Our Case Number: ACP-324383-26

Re: Proposed IDA Belview Infrastructure Development
Belview, Slieverue, County Kilkenny

Application Reference: Section 177AE_IDA Belview Infrastructure Development

Proposed works: Access infrastructure to industrial land bank, upgrading the L3412 public road to a dual-lane carriageway, and installation of Active travel walk/cycle lanes

Title: **Proposed Access Road Layout Masterplan**

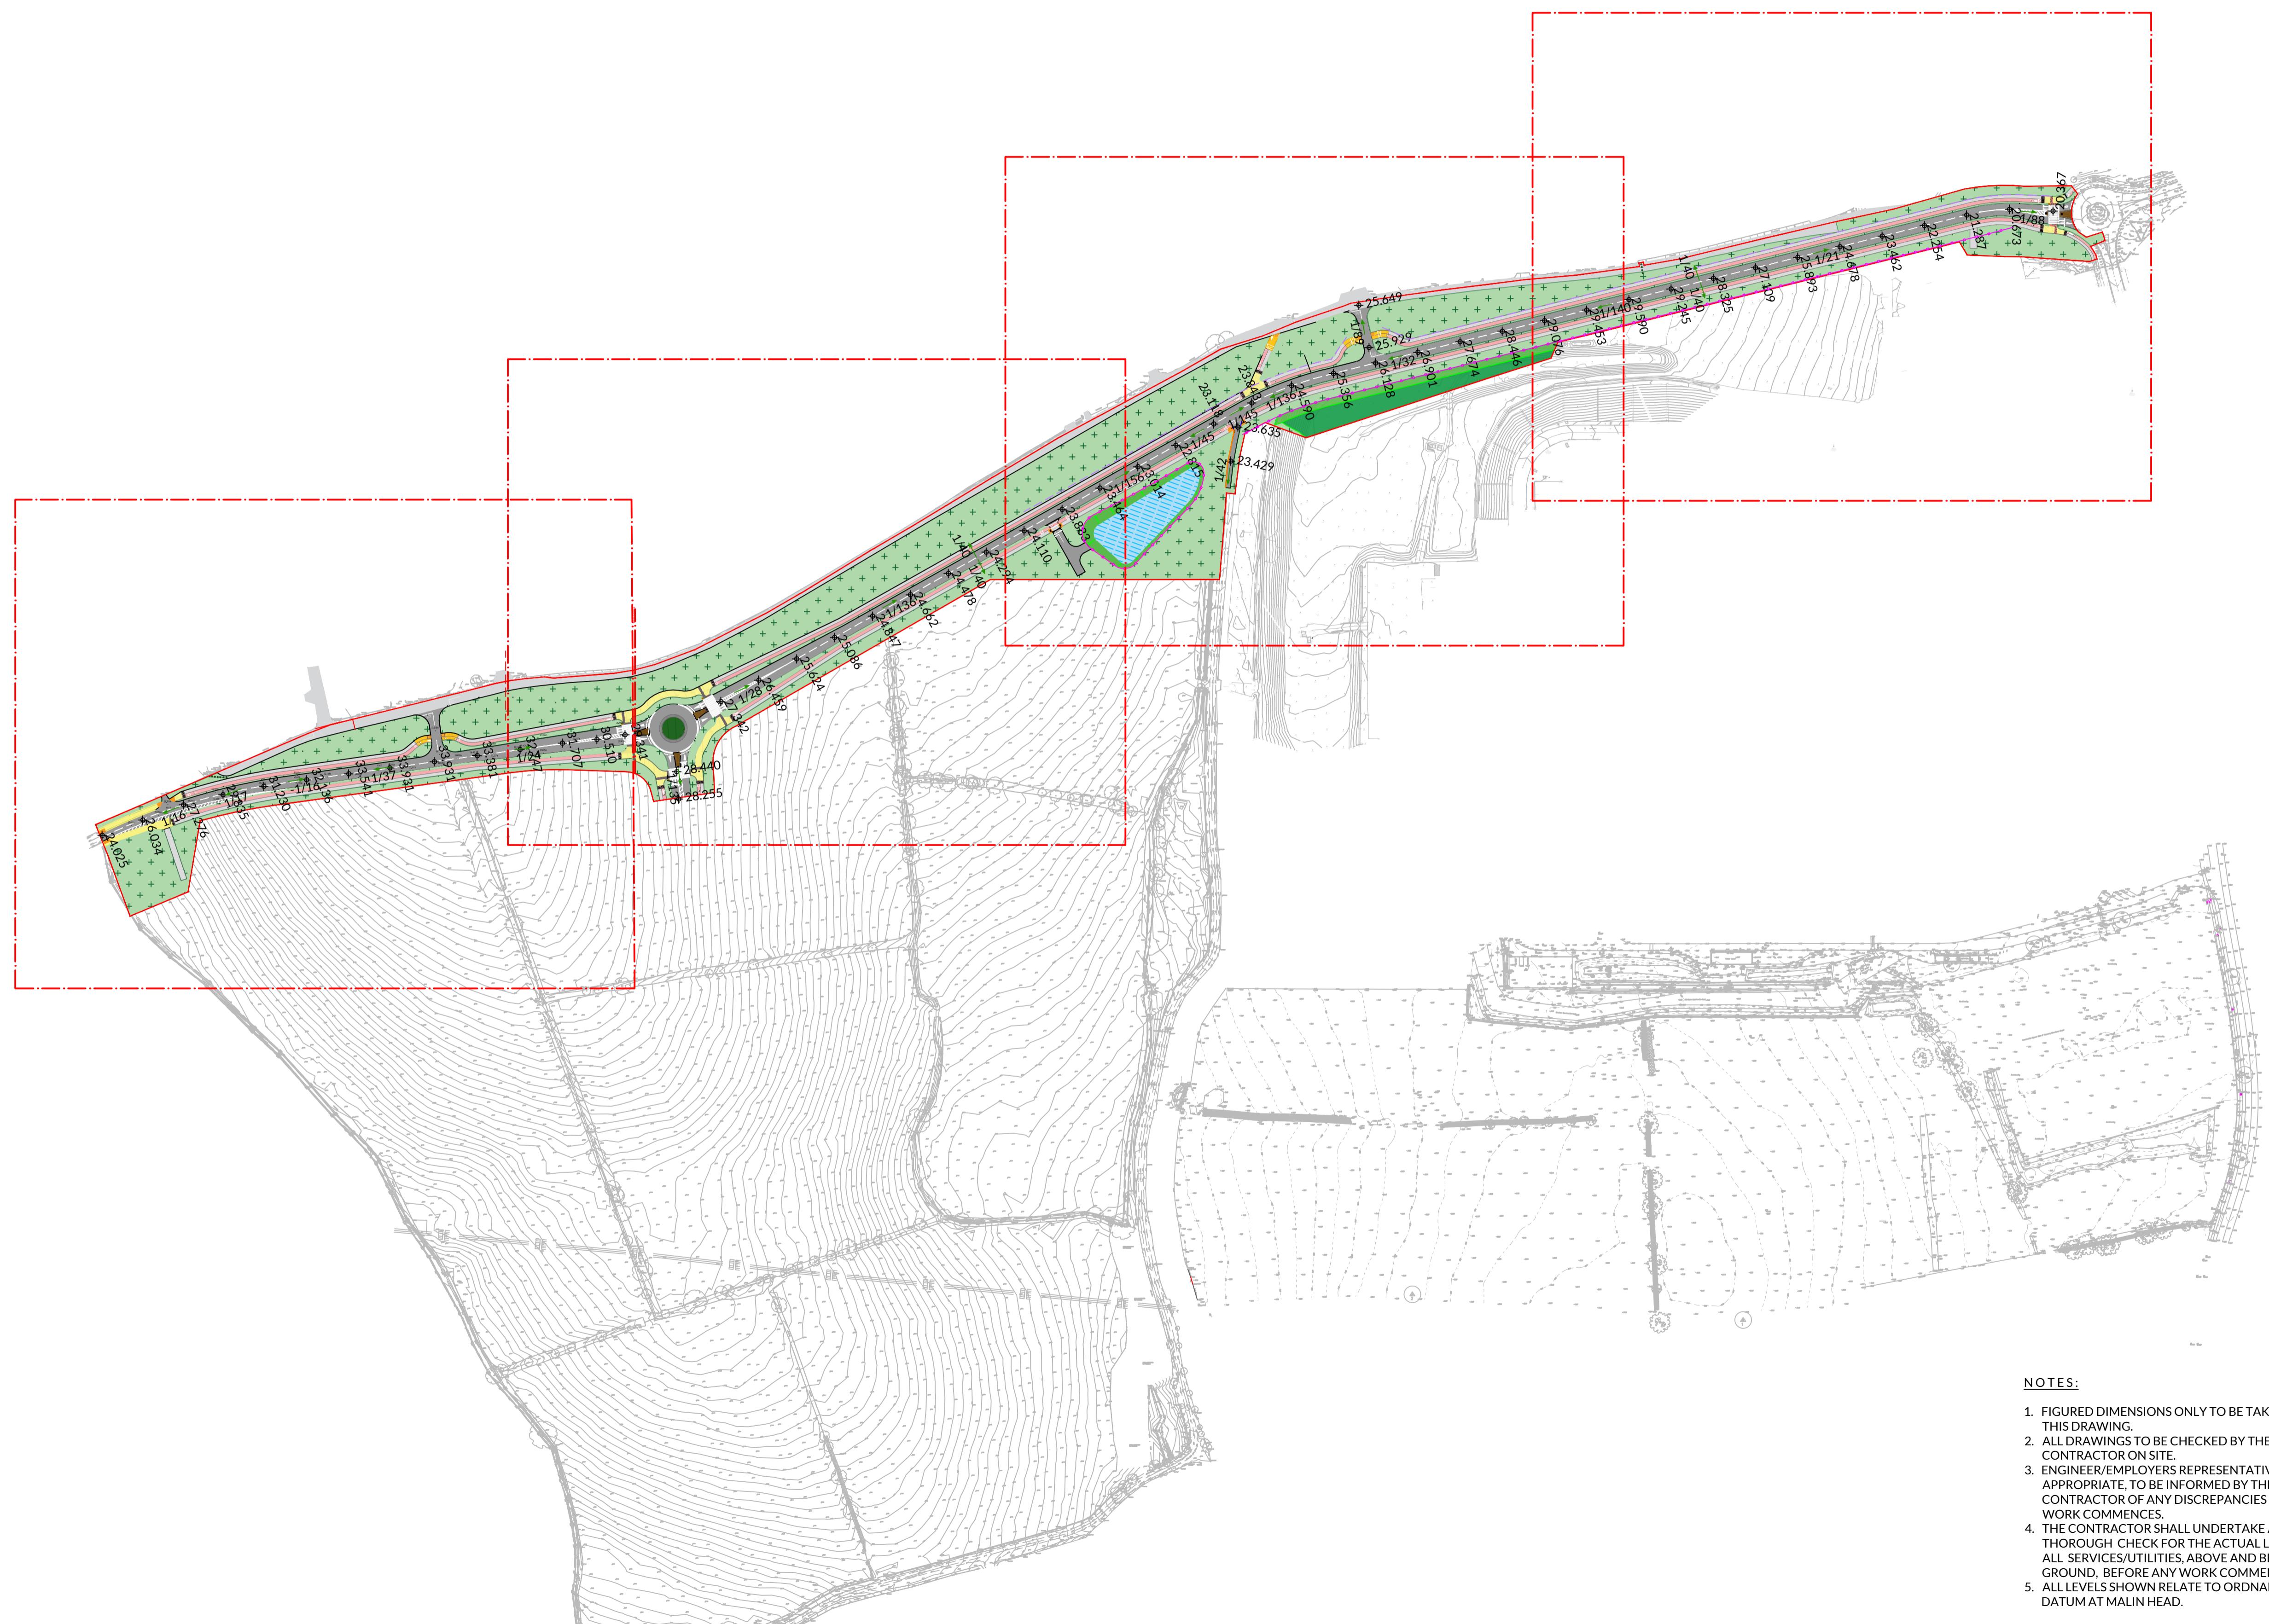
Kilmurry the site will directly overlook our communities. We request strict planning condition requiring that all perimeter boundary embankments particularly along the southern boundary facing down toward Gyles Quay be adequate for purpose with a minimum depth of 15 -25 meters. We would like to see the current berm banks extended and a new one planted with mature, native trees when ground is broken on the new IDA site to form an immediate visual and acoustic shield.

Title: **Proposed Access Road Layout Sheet 1 of 2**

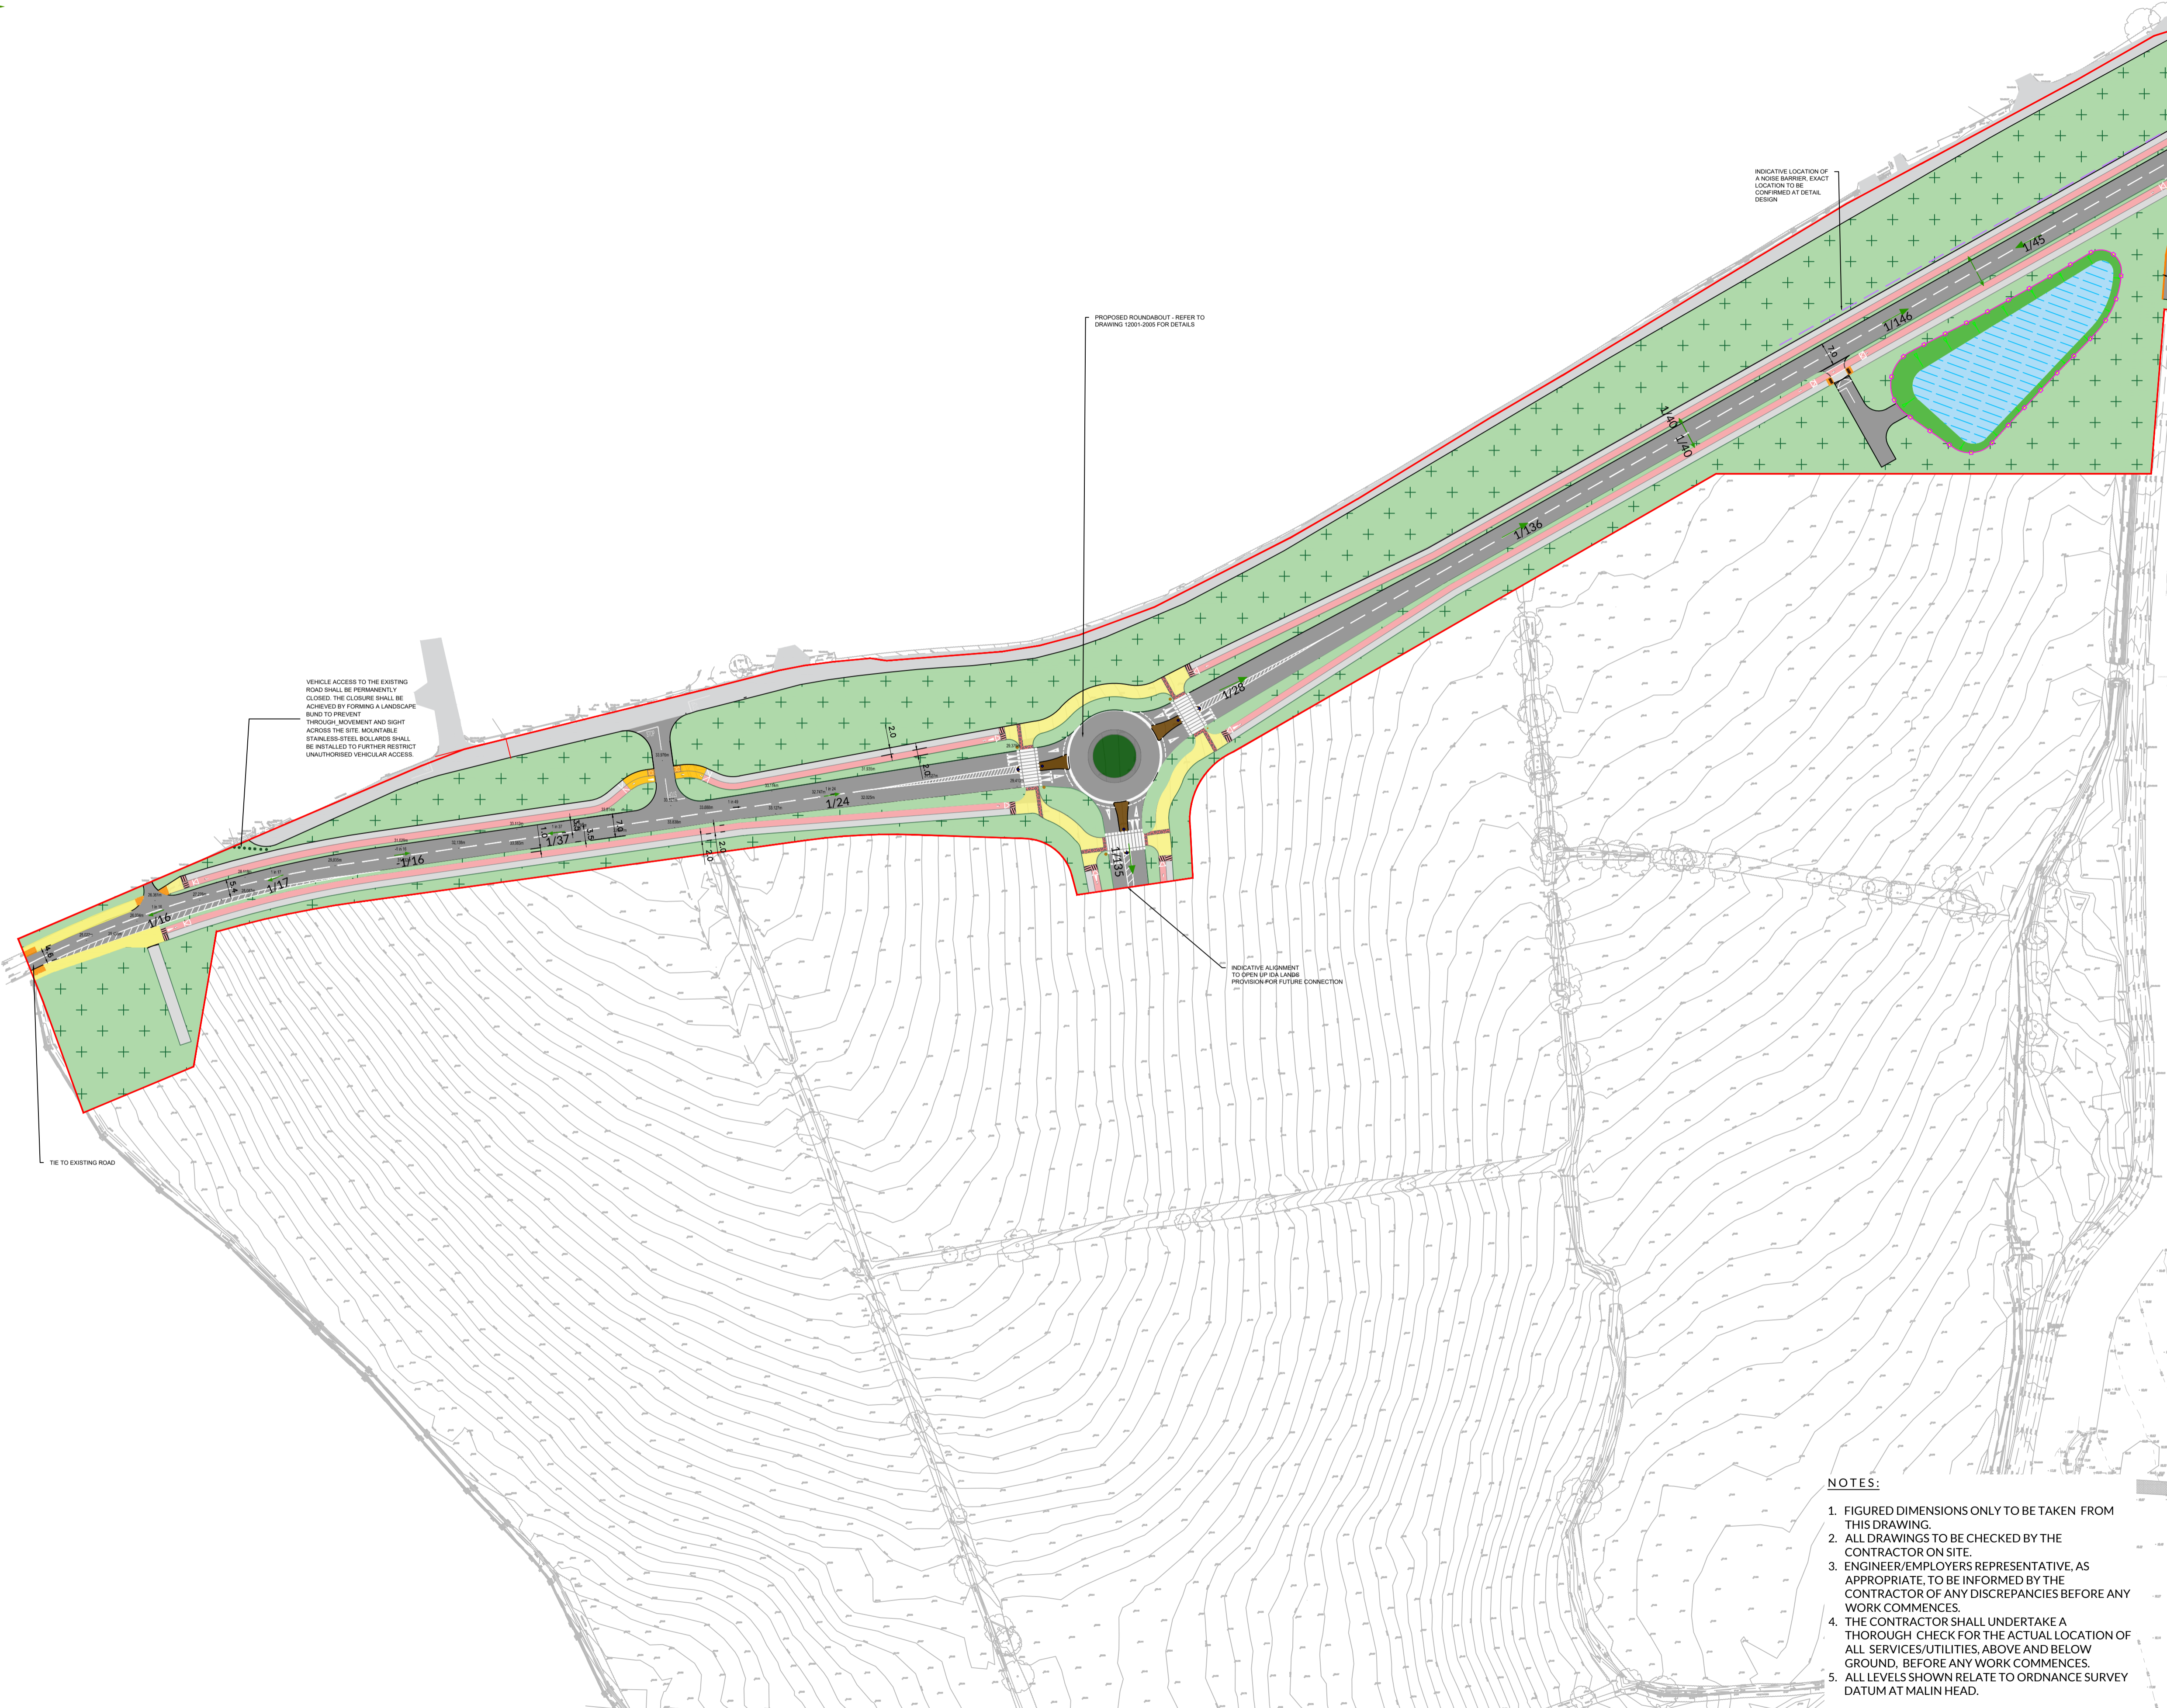
The upgrading of the L3412 to a dual motorway must not compromise the integrity of our community's local connectivity. We would like to see planning reassurances that our by road the L7476 will not be dissected, closed or Cul De Sacked at a later stage as individual plots within the IDA park are developed. Furthermore, Industrial traffic must be physically restricted from routing south through Gyles Quay to preserve road safety and residential amenities. We would also like to see a 3-tonne vehicle cap on traffic heading west towards Ferrybank after the L3412 is upgraded and during construction.
